MOSMAN MUNICIPAL COUNCIL

22 February 2008

Re: Proposed upgrade and Expansion of the d'Albora Marina, The Spit, Mosman

The following is a response to your correspondence dated 7 February 2008 wherein you requested that Council provide input to the Director General's requirements for the proposed upgrade and expansion of the d'Albora Marina proposed by Macquarie Leisure Operations Limited.

job no	DMS	drawing no	DA02
drawn	cc	issue	G
checked	mmk		
scale	1:200		
@	A1

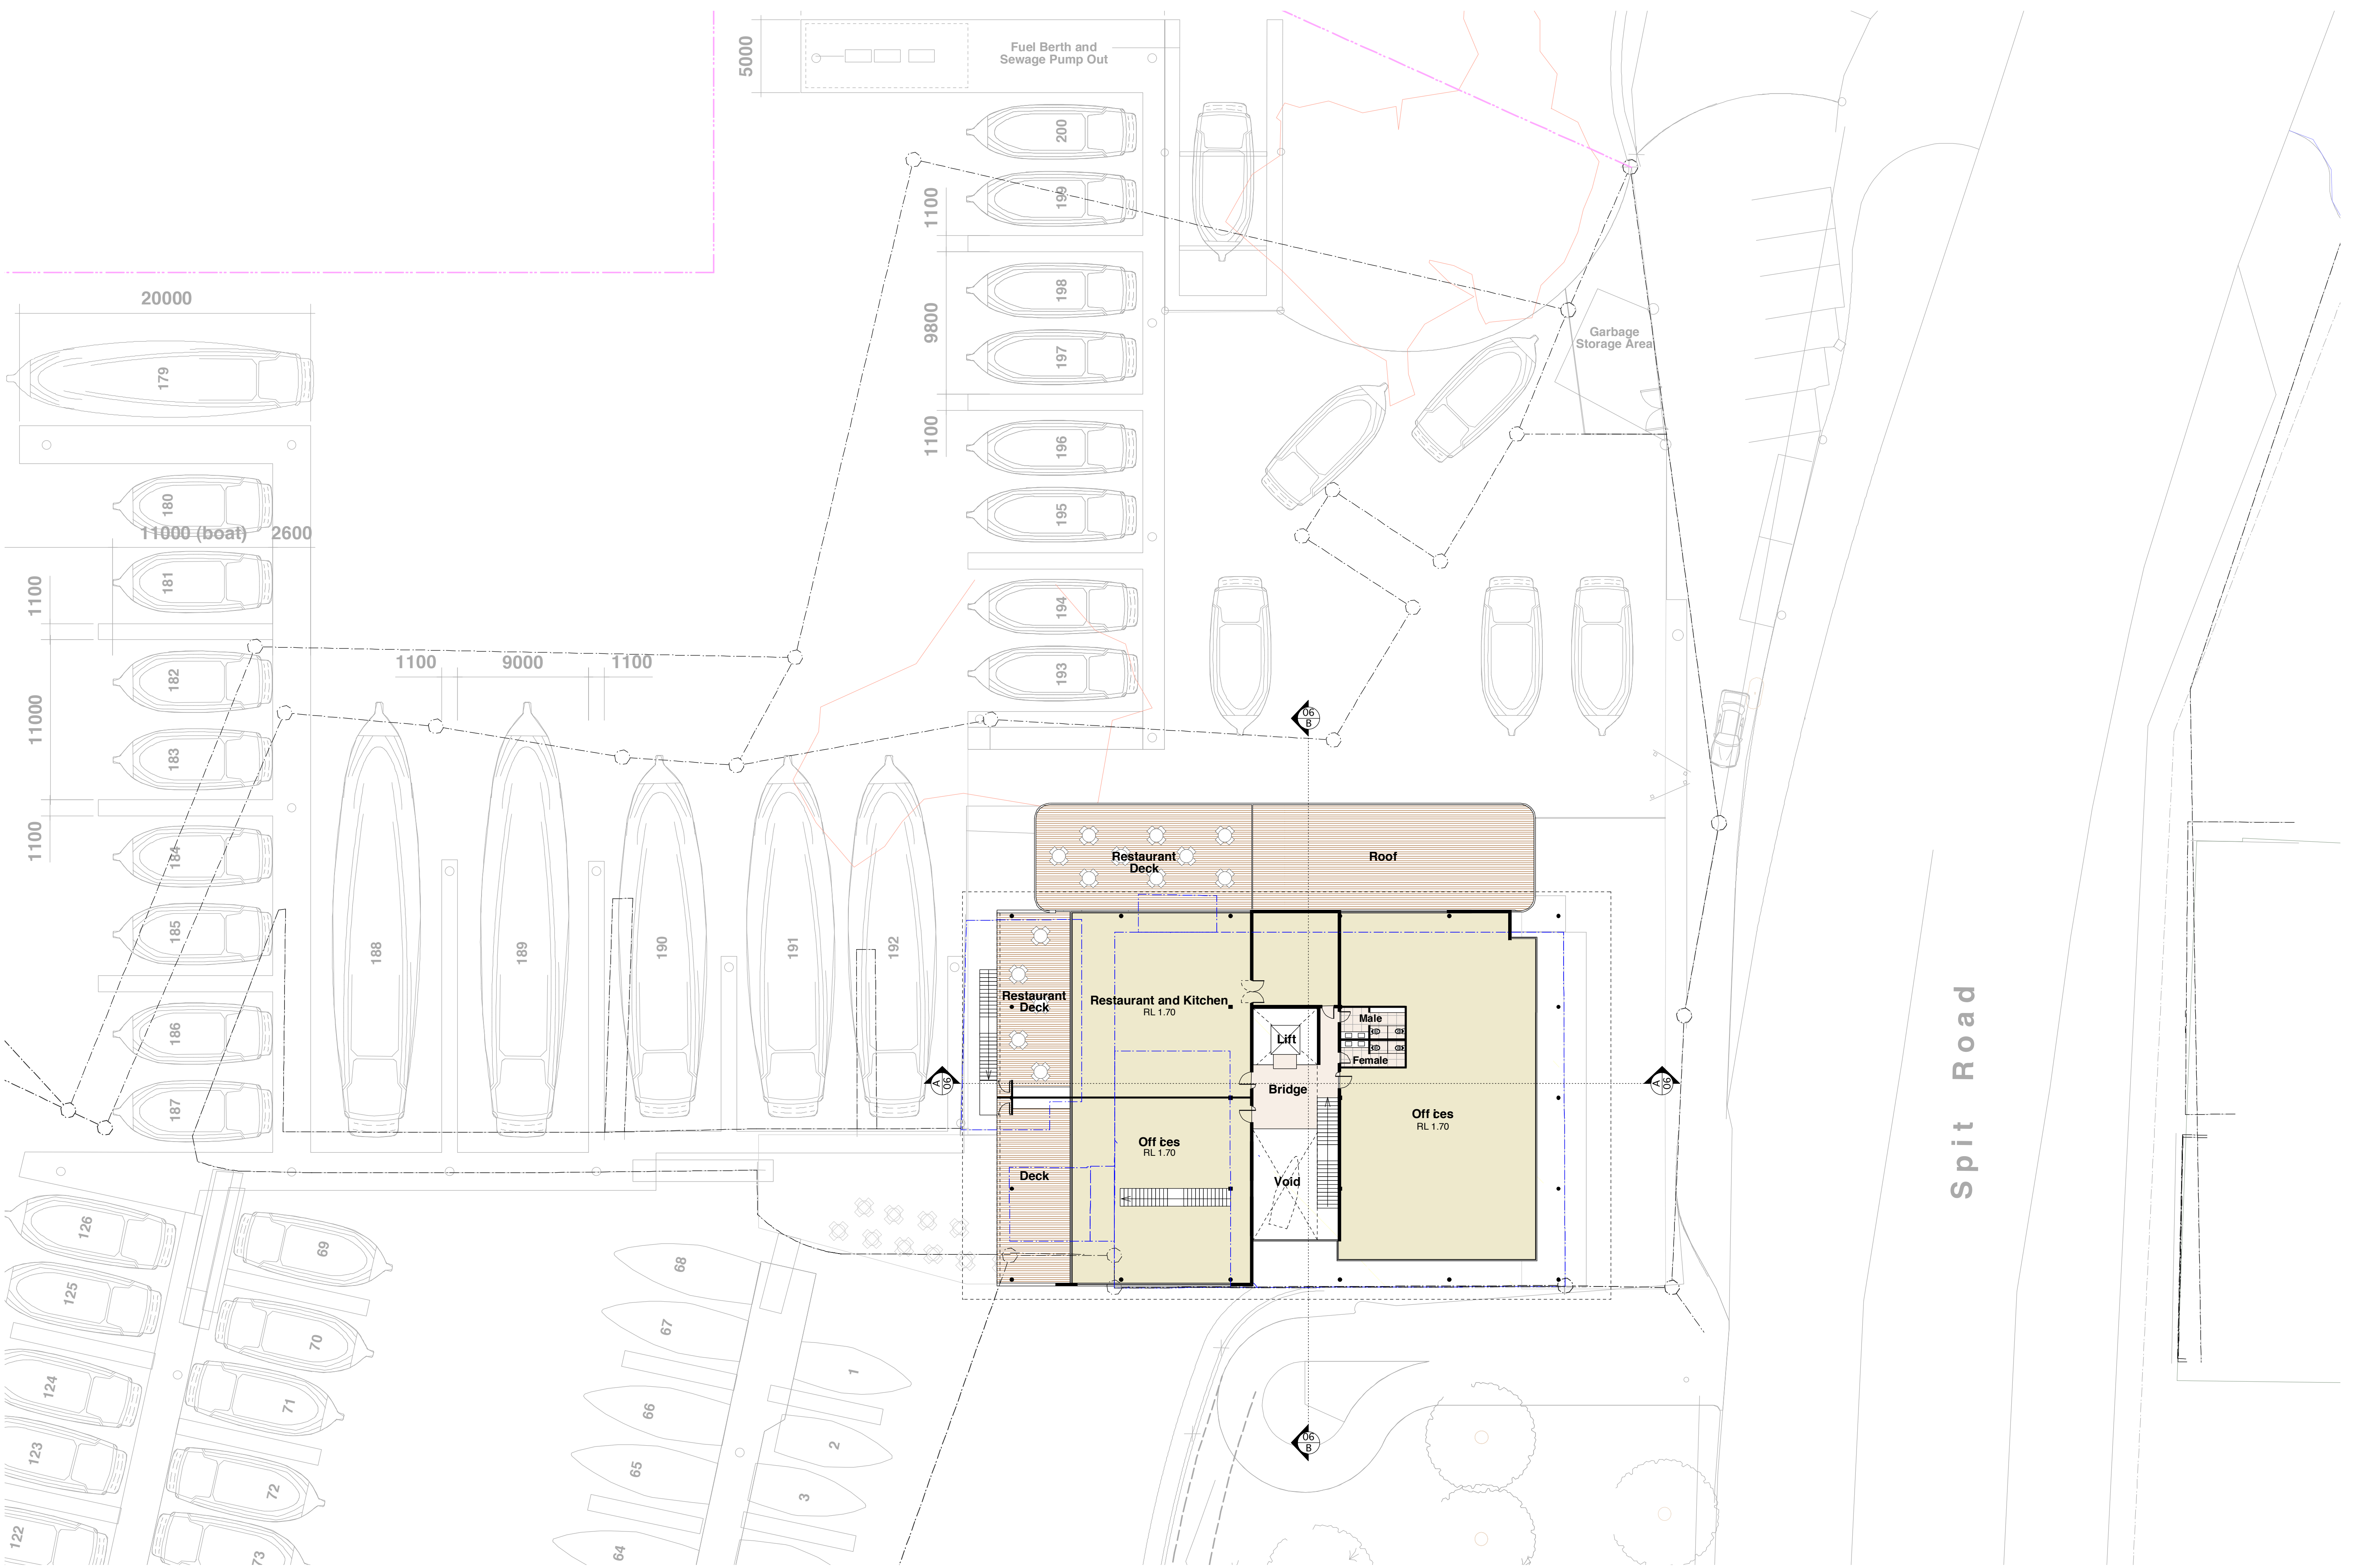
Whether the proposal maintains and improves public access to and along the foreshore is an issue. Drawing No. DA02 Issue C does not identify unobstructed public access along the foreshore.
